**Planning consultation: Application by One Earth Solar Farm Limited for One Earth Solar Farm. The Examining Authority's request for information and follow up to Examiner's Question 3.**

**Location: One Earth Solar Farm**

## Annex A: Natural England's Response to the Examining Authority's Third Written Questions

# Annex B: Natural England's Updated Comments on Cumulative Assessment of Soils from D4

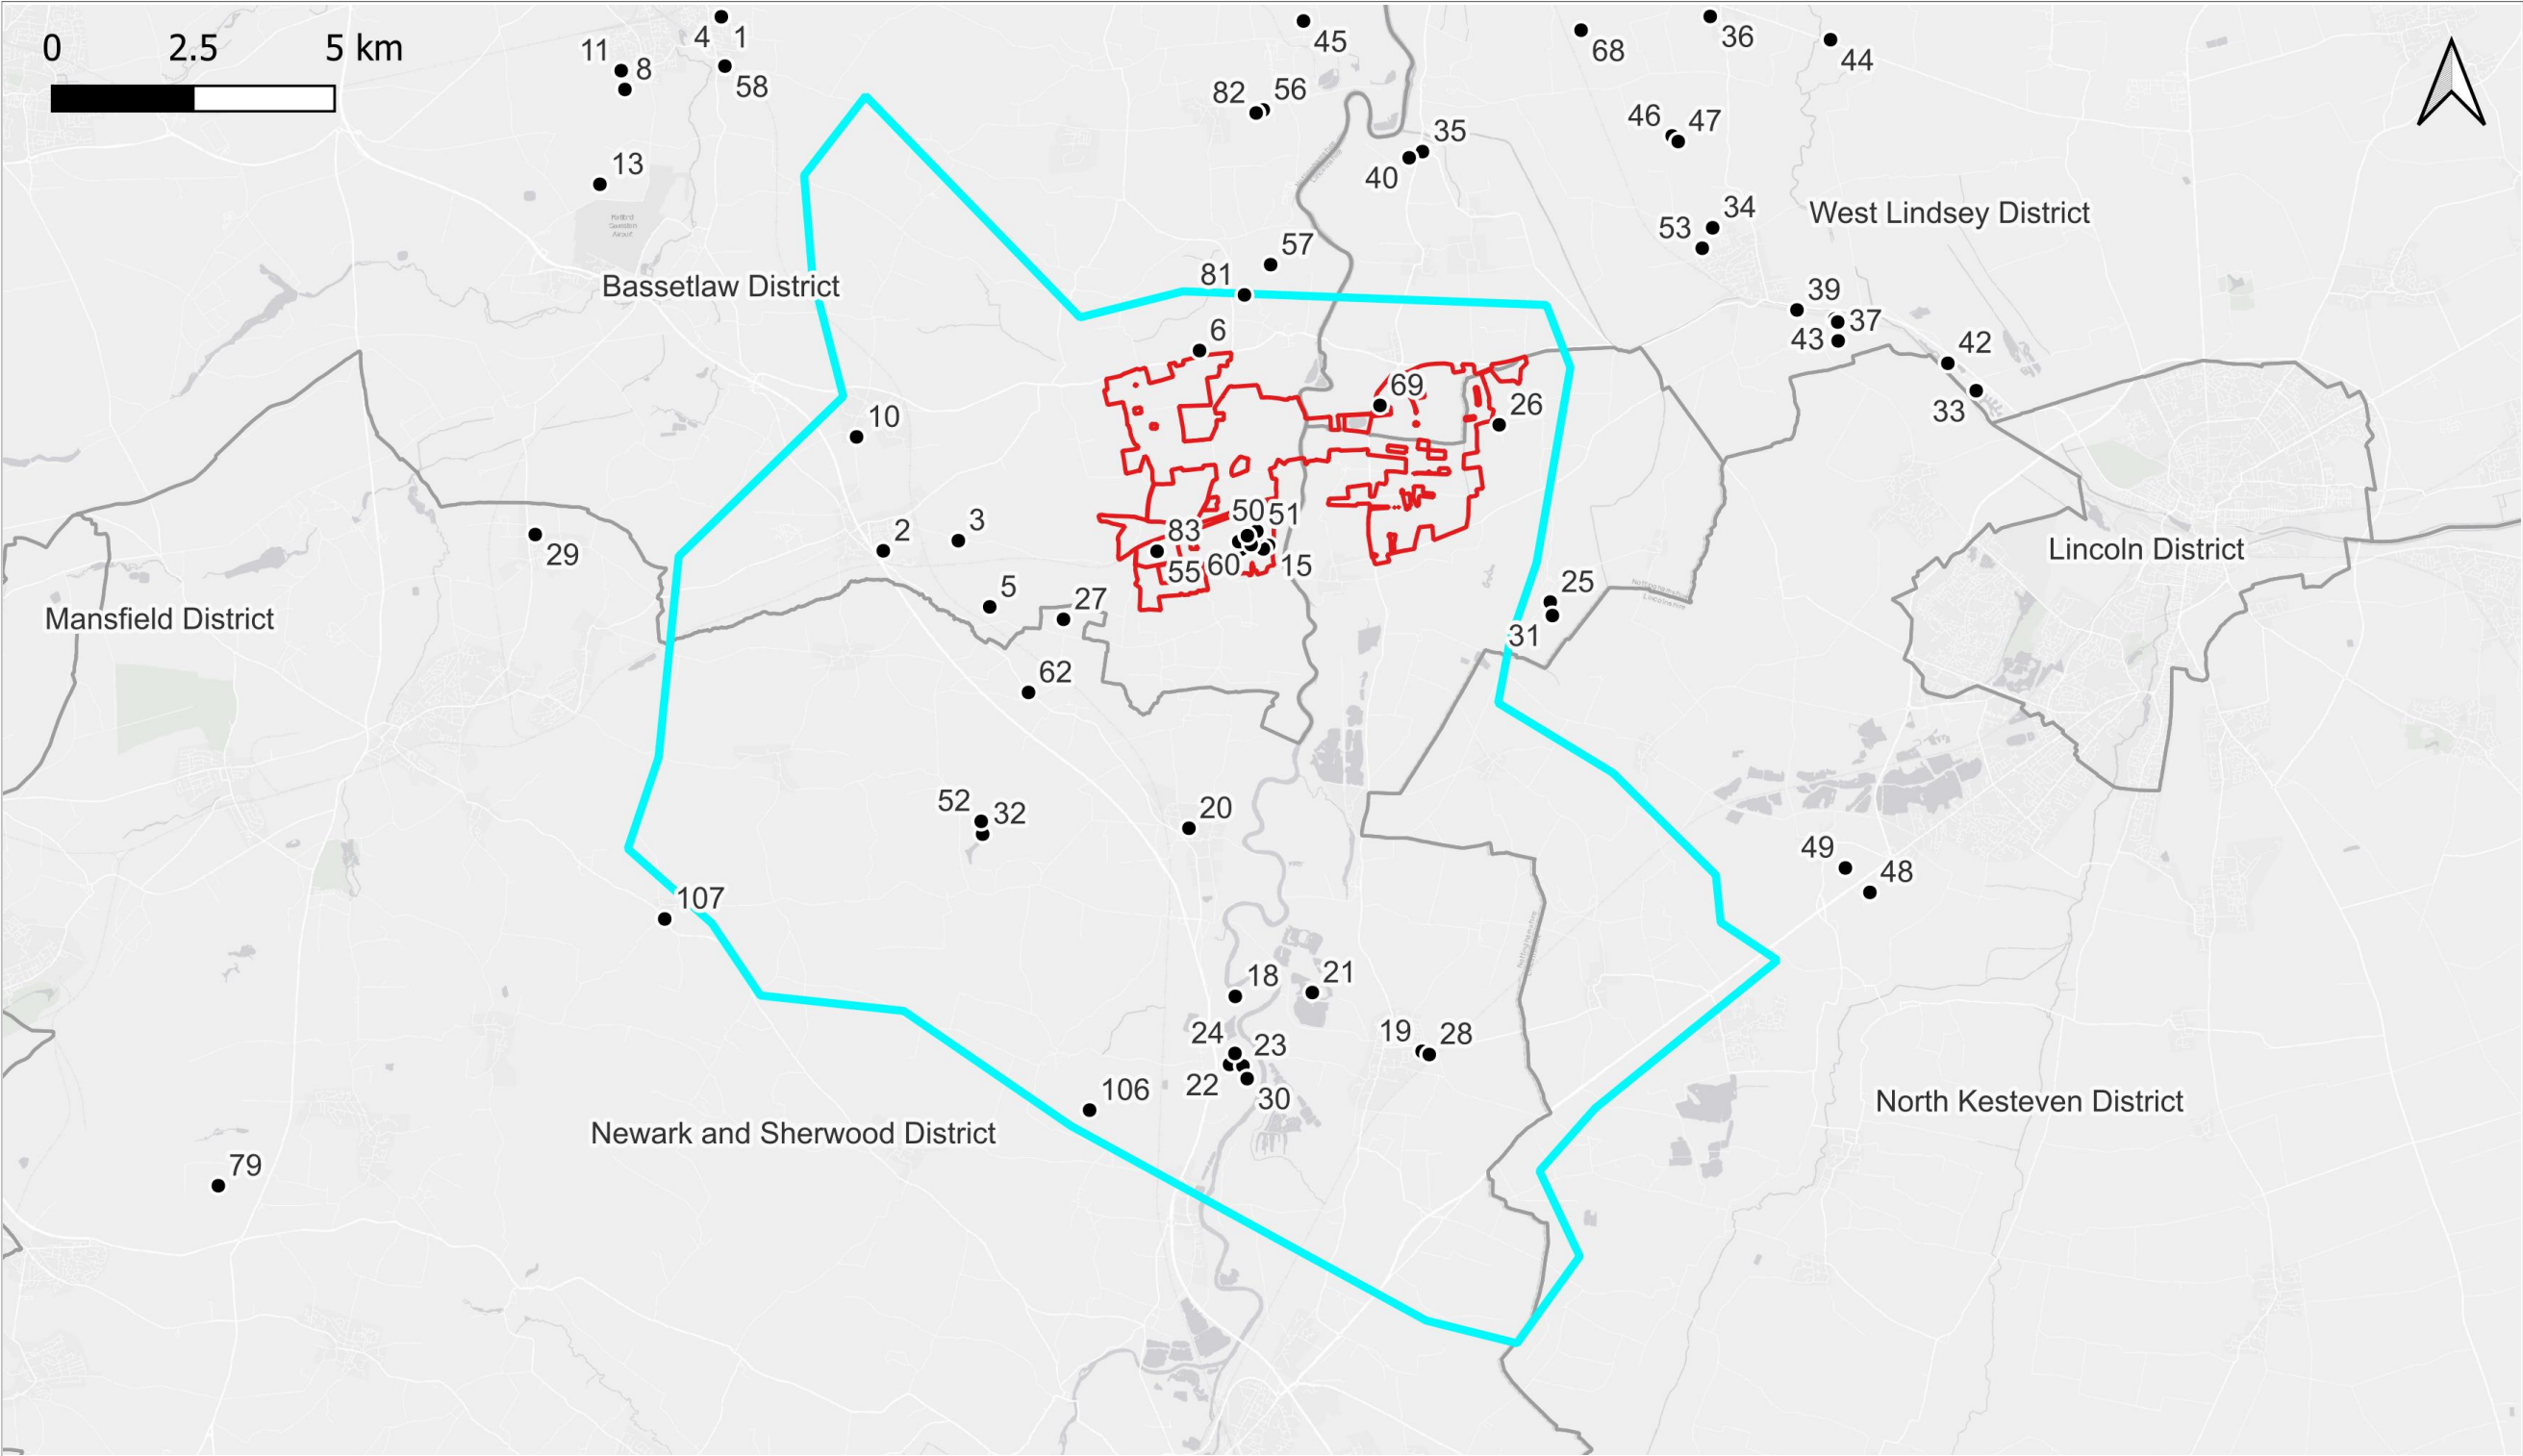
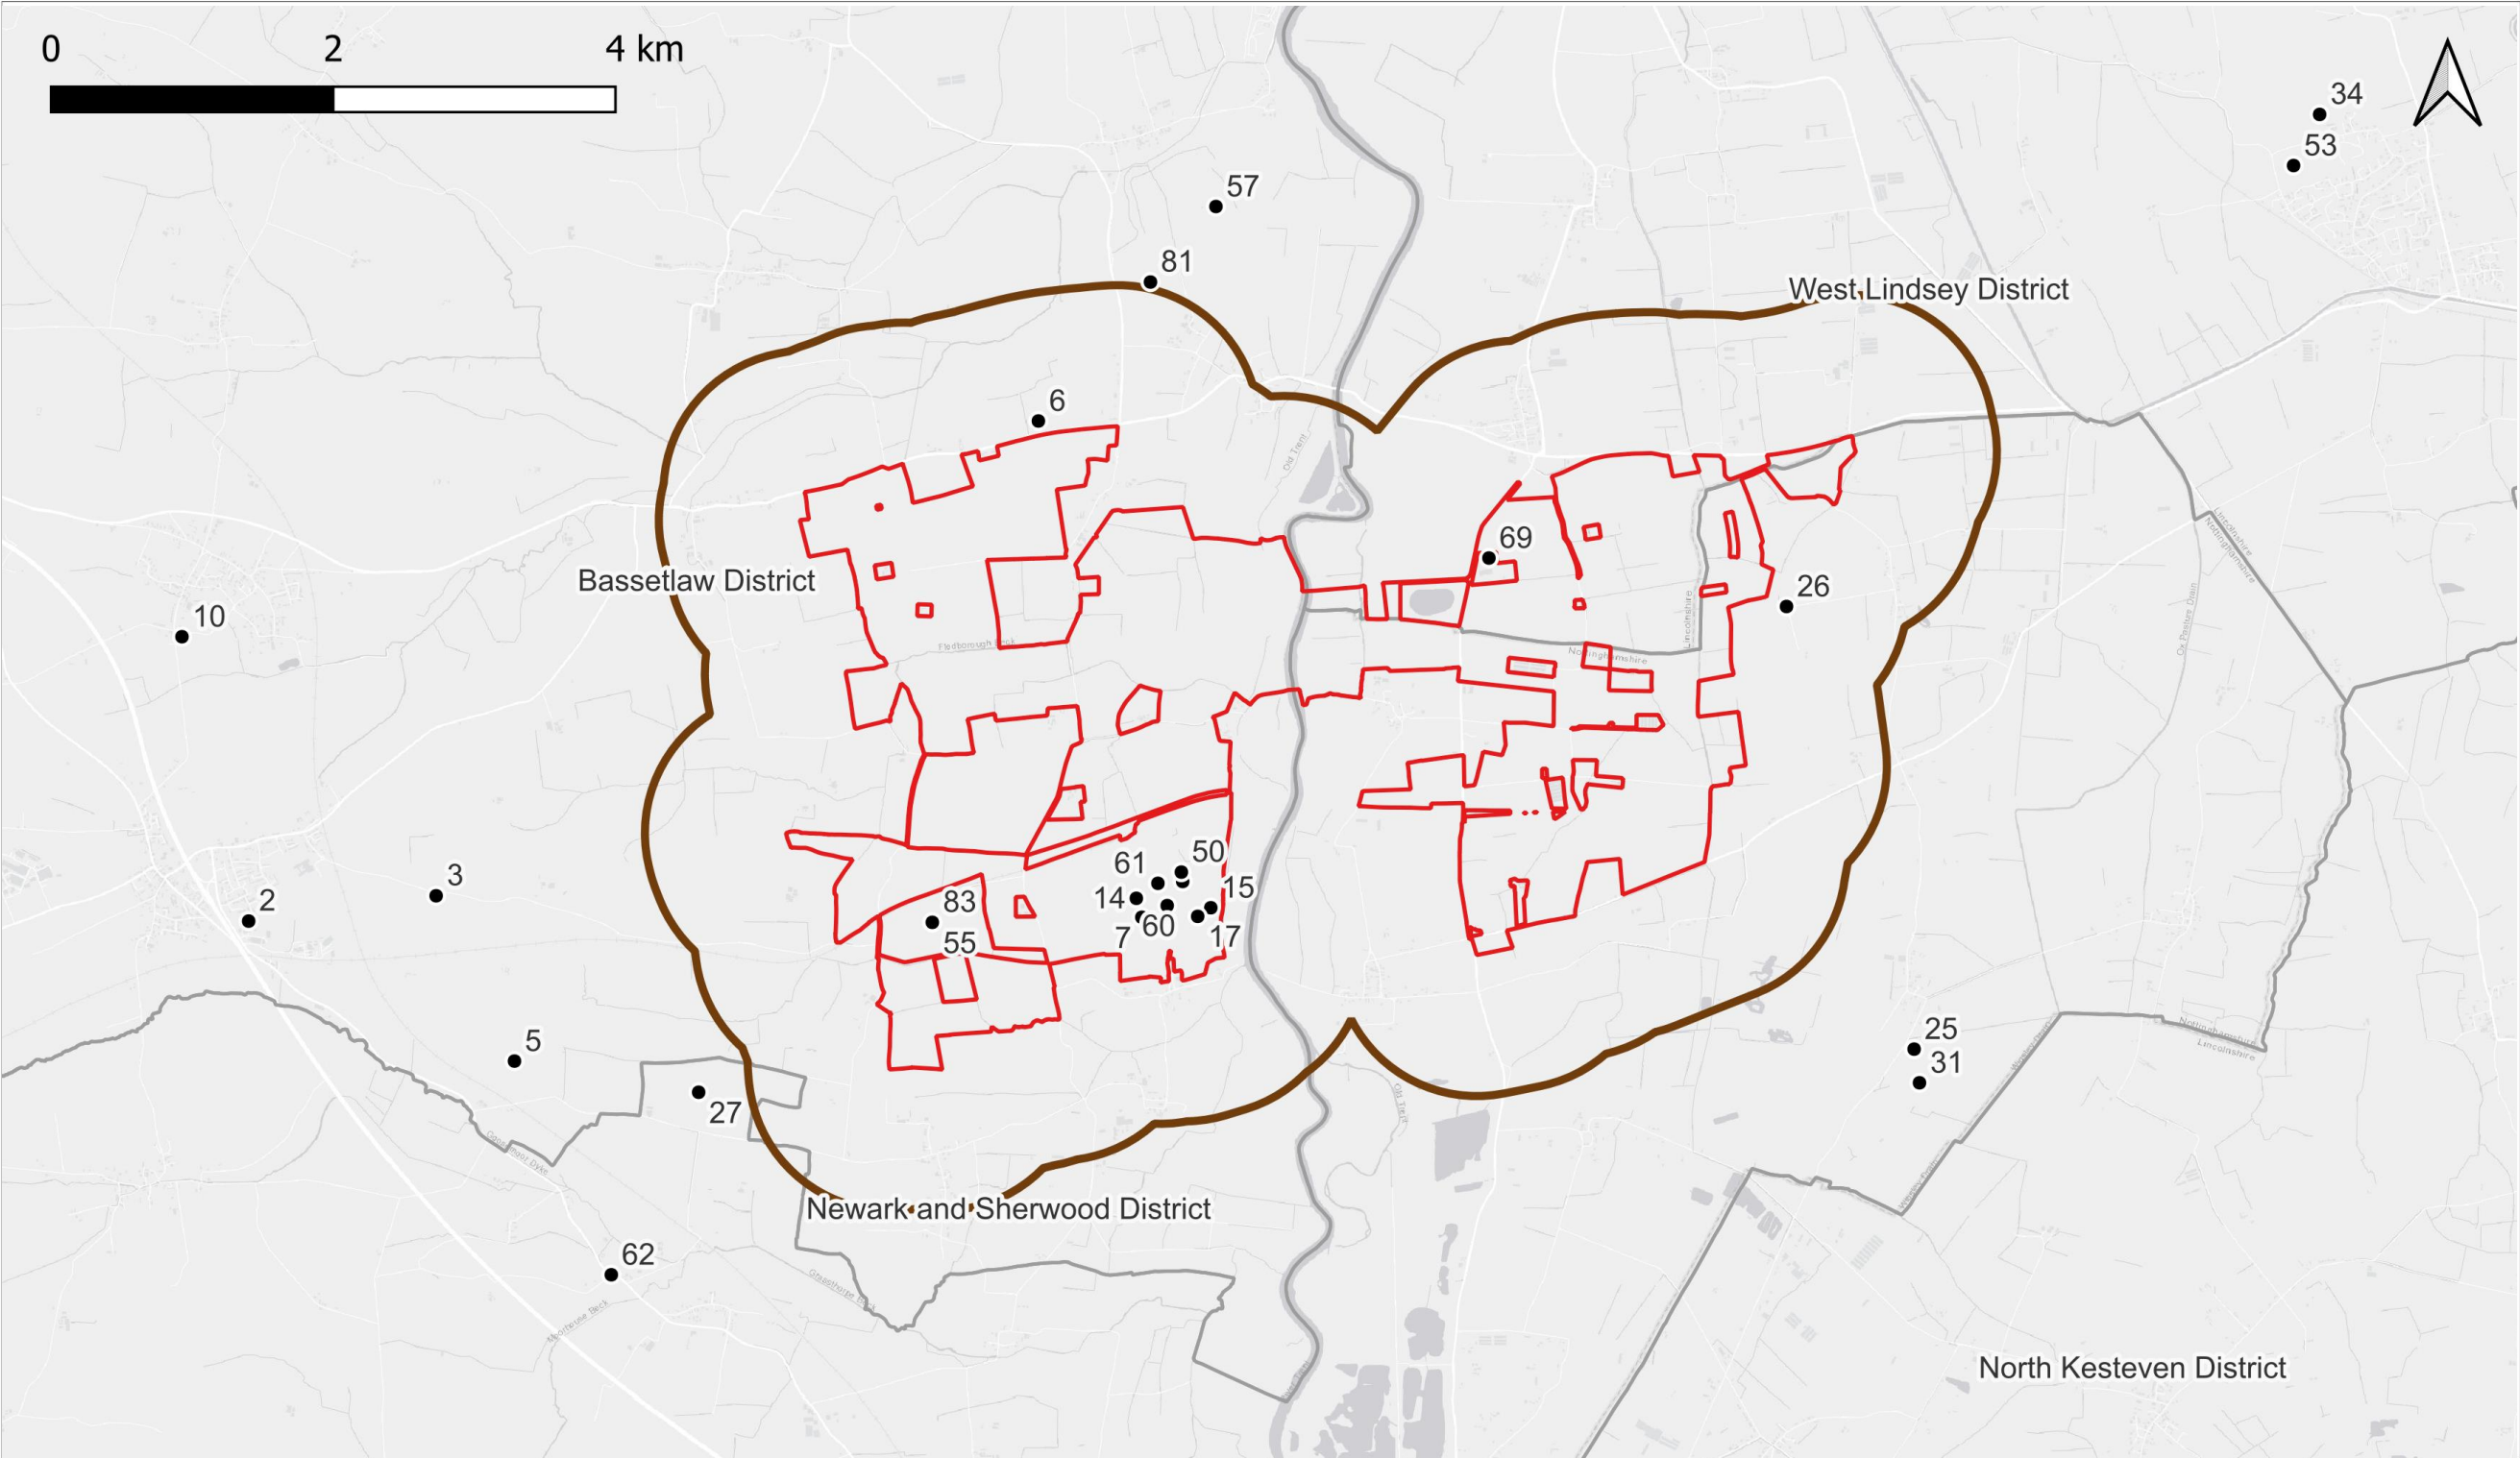
**18.3.19** Natural England are broadly satisfied with the regional Zol and the information provided within ES Volume 3, Figures 18.1 to 18.8 [EN010159/APP/6.20] for a regional cumulative assessment, however we refer the applicant back to the comment above (table 18.2)

D6 Update: No further comment.  
D7 Update: No further comment.
